City of Portland, Maine - Building or Use Permit Application
 389 Congress Street, 04101 Tel: (207) 874-8703, Fax: (207) 874-8716

Permit No: 10-0032	Issue Date:	CBL: 399 E003001
------------------------------	--------------------	----------------------------

Past Use: Single Family Home - connected w/ permit #090823	Proposed Use: Single Family Home - Amendment to permit #090823 add rear deck, relocation of bulkhead, relocated & modified front entry, field inlet placement, changed driveway	Permit Fee: \$40.00	Cost of Work: \$1,200.00	CEO District: 4
Proposed Project Description: Amendment to permit#090823 add rear deck, relocation of bulkhead, relocated and modified front entry, field inlet placement, changed driveway		FIRE DEPT: <input type="checkbox"/> Approved <input type="checkbox"/> Denied	INSPECTION: Use Group: Type	
		Signature:	Signature:	
PEDESTRIAN ACTIVITIES DISTRICT (P.A.D.)				
Action <input type="checkbox"/> Approved <input type="checkbox"/> Approved w/Condition <input type="checkbox"/> Denied				
Signature: Date:

Dept: Zoning **Status:** Approved with Conditions **Reviewer:** Ann Machado **Approval Date:** 01/13/2010
Note: **Ok to Issue:**

SCALE: 1" = 20'	APPROVED BY: REVIEWED: 01-28-2008 TO SHOW PROPOSED LOT AND BUILDING	DRAWN BY
DATE: 01-15-2008		REVISED
BY: DANIEL J. DALFONSO LLC LAND SURVEYOR B7A OCEAN STREET SUITE 204 SOUTH PORTLAND MAINE 04106		
		DRAWING NUMBER 1216

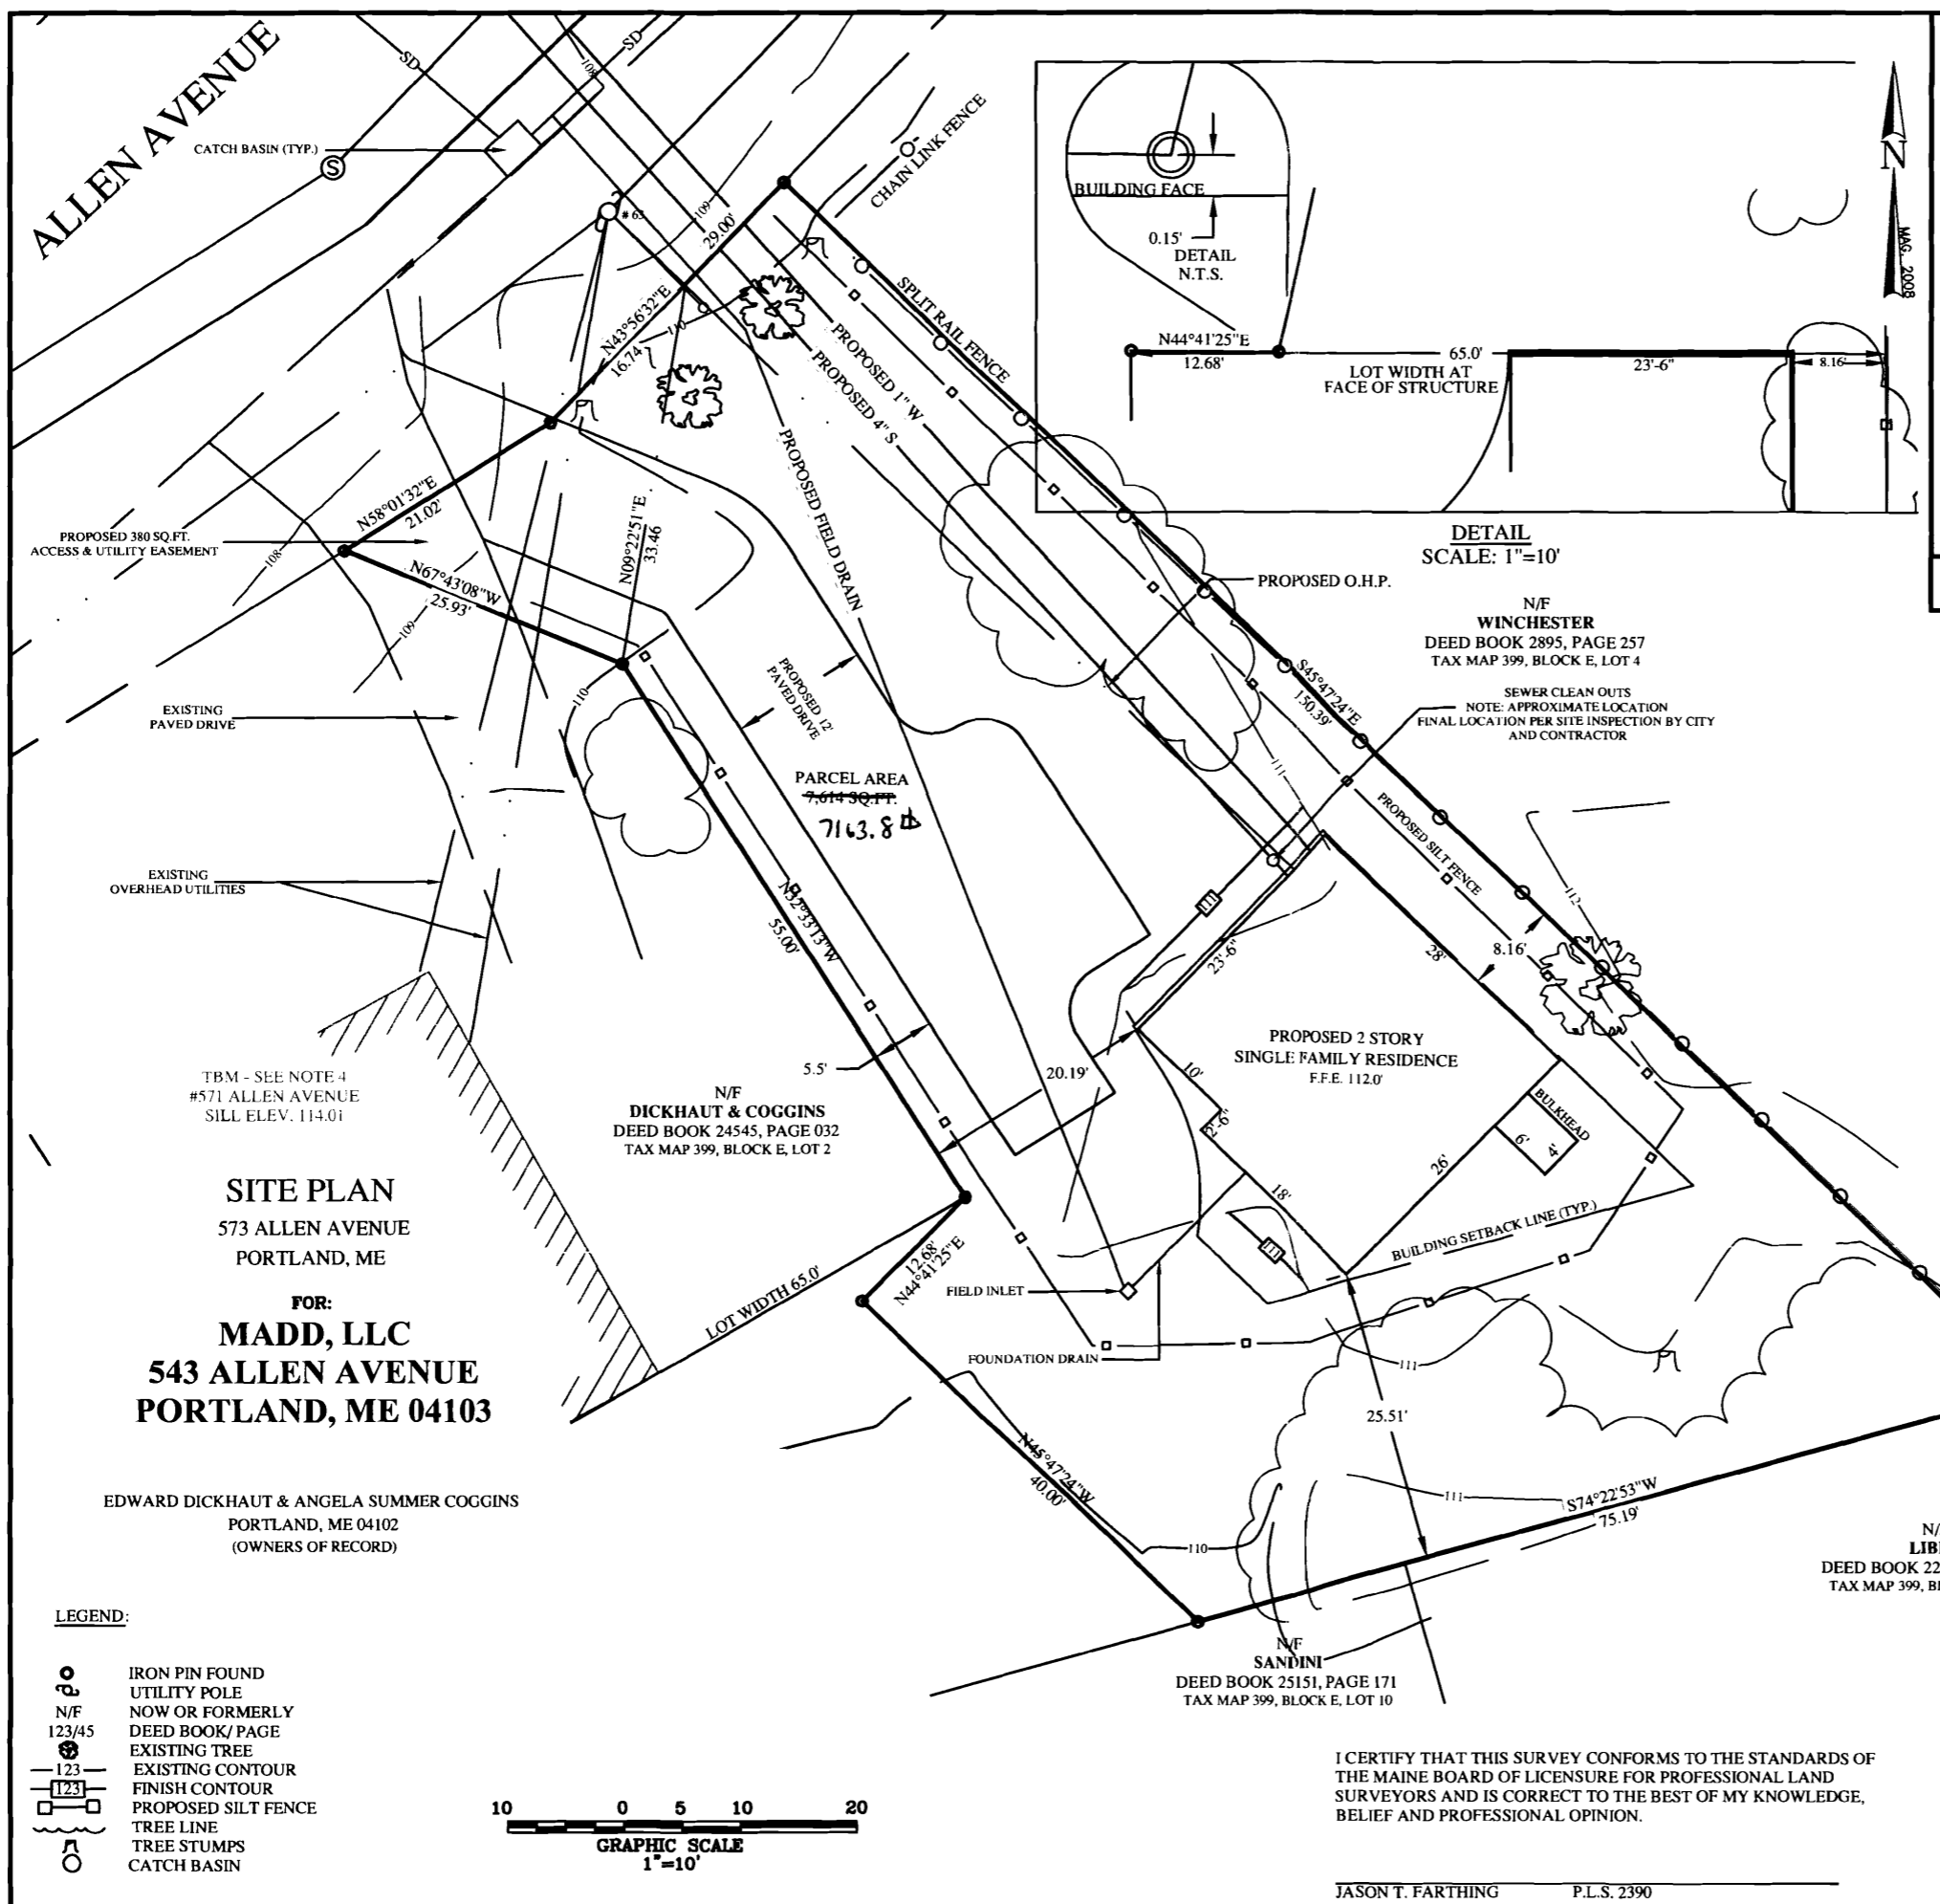
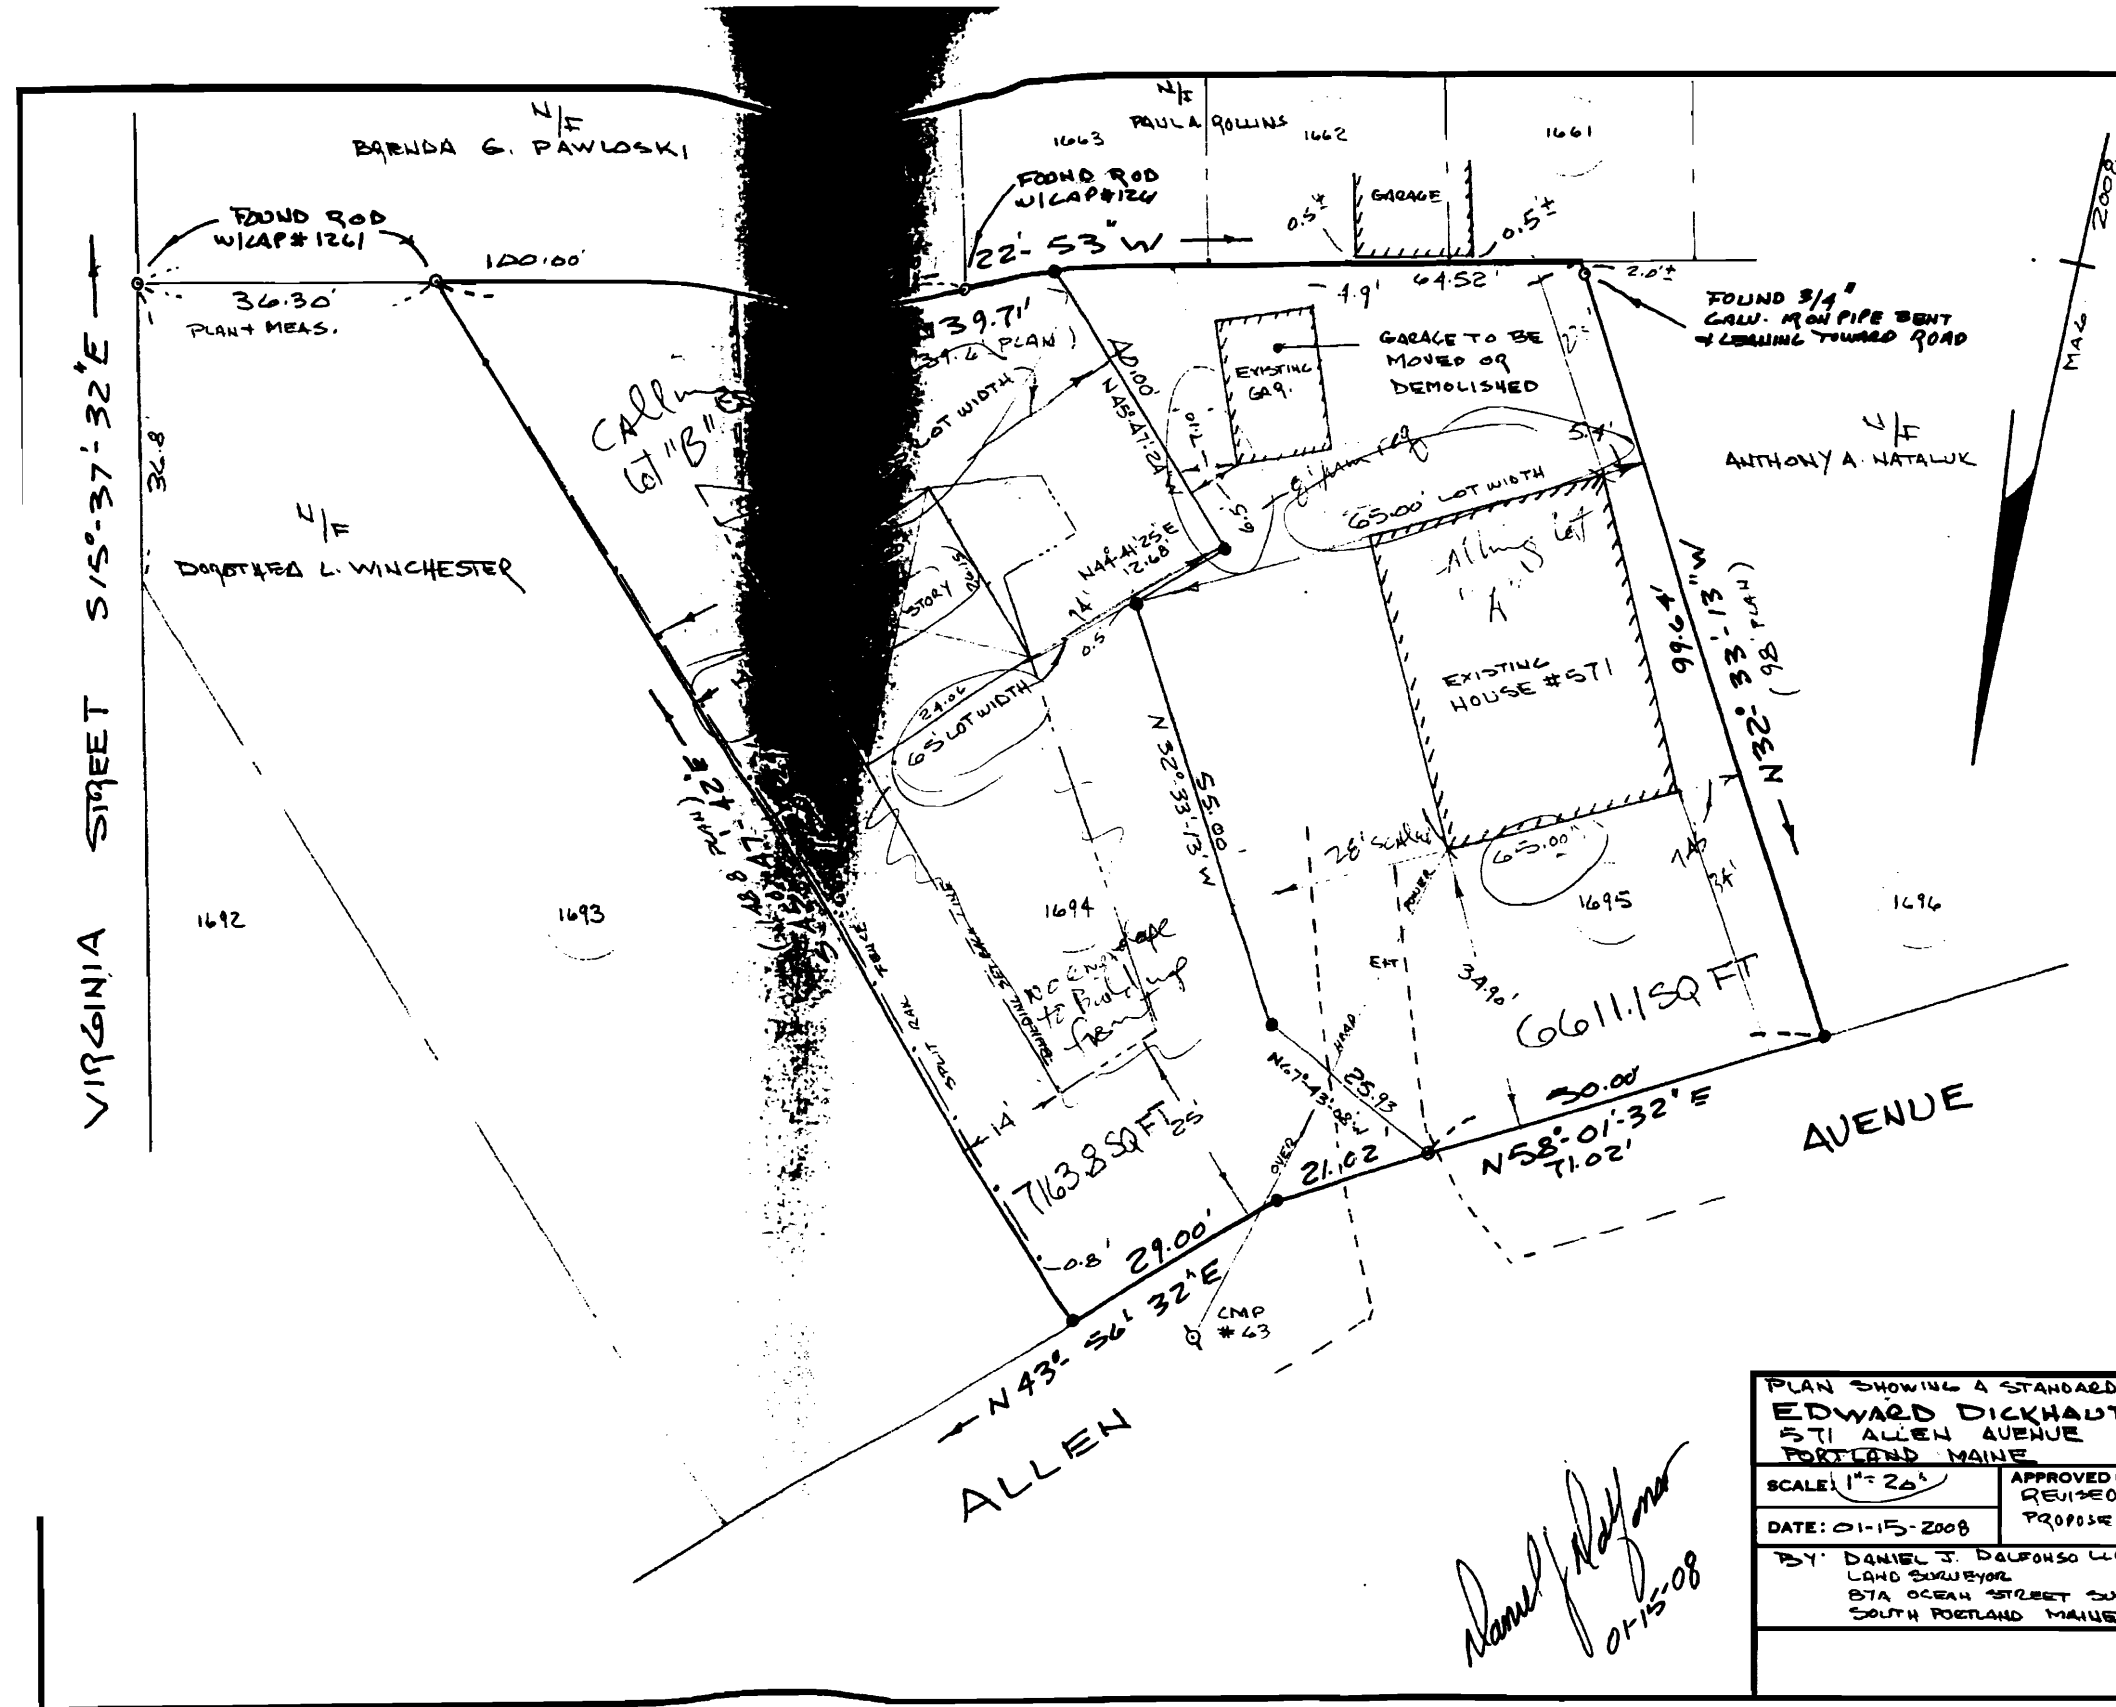
1/12/2010-amachado: New driveway does not meet zoning requirements.

1/13/2010-amachado: Spoke to Dan Anderson. Can pave within 5' of property line, just can't park there for the first 50'. Parking at the end of the driveway near the house needs to be 18' wide and 19' deep to accommodate two tandem spaces. Need revised siteplan to show that.

1/13/2010-amachado: Moved permit forward in the review process but can't sign off without revised siteplan showing that the parking requirement is being met.

1/13/2010-amachado: Dan Anderson submitted a siteplan that shows the parking is being met.
